Ribble Valley Borough Council
By email

Your ref 3/2026/0230
Our ref DC/26/1427
Date 28-AUG-26

Location: Land to the south of Ribblesdale Primary School west and north of Higher Standen Drive

Proposal: The erection of 60 dwellings comprising houses, bungalows, flats, related infrastructure (including public open space) and landscaping

Drawing file: planx_downloads / 26_0230_P26127DGCZ1GFDRC0001P05_Drainage_Strategy_Plan_5Aug26.pdf

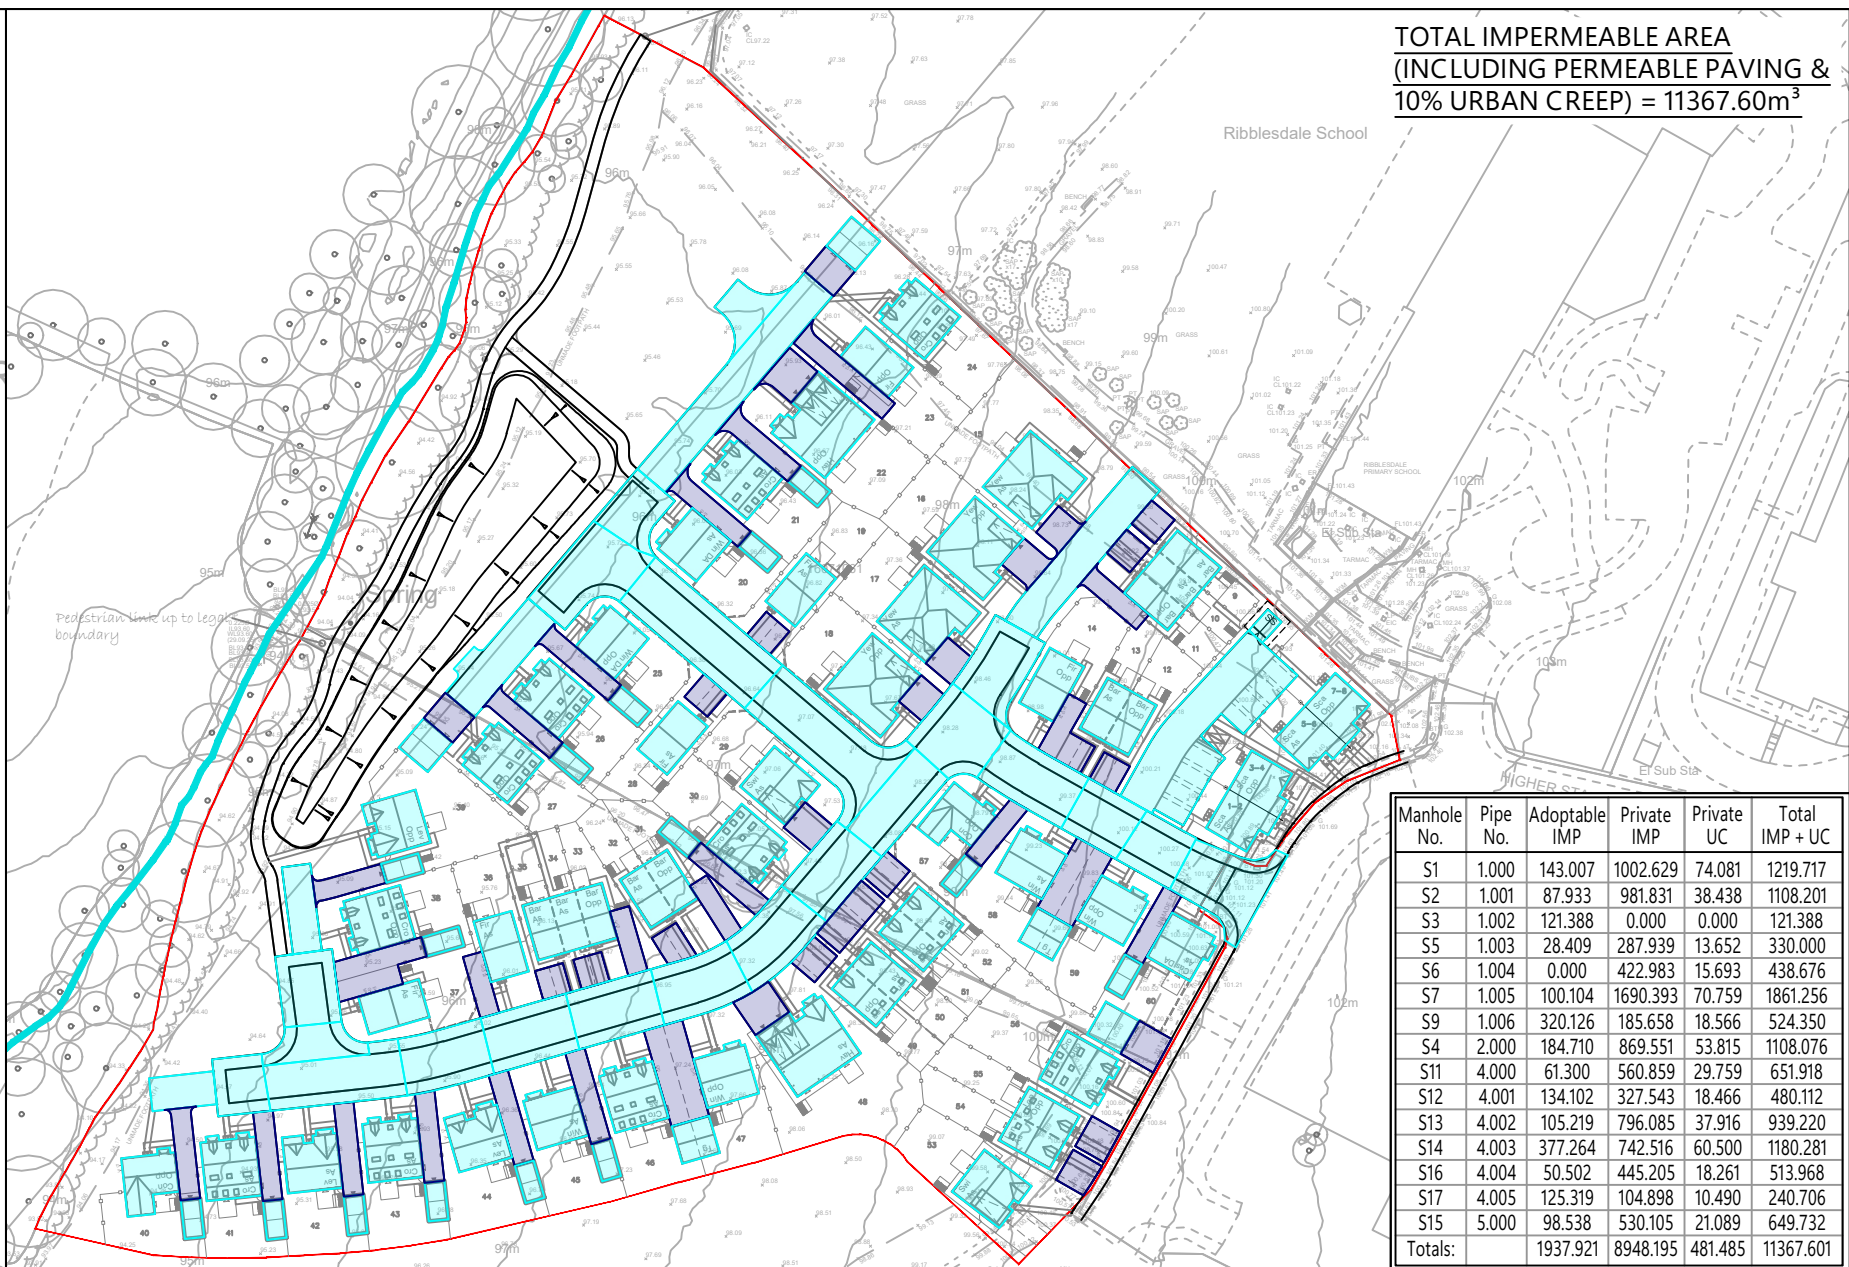
Following our review of the submitted Drainage Strategy, we can confirm that whilst the strategy for the disposal of foul and surface water is acceptable in principle, there are elements of the detailed drainage design that might not be acceptable to United Utilities and will require resolution by the applicant. In particular this relates to the foul connection point. The foul connection point is to an unchartered/private sewer, please confirm where this discharges to the known network.

For this reason, and to avoid any unnecessary delays or costs for the applicant, we request that the proposed drainage strategy is not approved until such time as all concerns are resolved. The applicant should contact our Wastewater Developer Services team regarding this matter. See Appendix, Section 6.0 Contacts. Should planning permission be granted without resolution of all drainage concerns, we request the following condition is attached to any subsequent Decision Notice:

Prior to the commencement of development, details of a sustainable surface water drainage scheme and a foul water drainage scheme shall be submitted to and approved in writing by the Local Planning Authority. The drainage schemes must include:

- (i) An investigation of the hierarchy of drainage options in the National Standards for Sustainable Drainage Systems (or any subsequent amendment thereof). This investigation shall include evidence of an assessment of ground conditions and the potential for infiltration of surface water;***
- (ii) A restricted rate of discharge of surface water agreed with the local planning authority (if it is agreed that infiltration is discounted by the investigations);***
- (iii) Levels of the proposed drainage systems including proposed ground and finished floor levels in AOD;***
- (iv) Incorporate mitigation measures to manage the risk of sewer surcharge where applicable;***
- (v) Details of points of discharge for foul and surface water;***
- and***
- (vi) Foul and surface water shall drain on separate systems.***
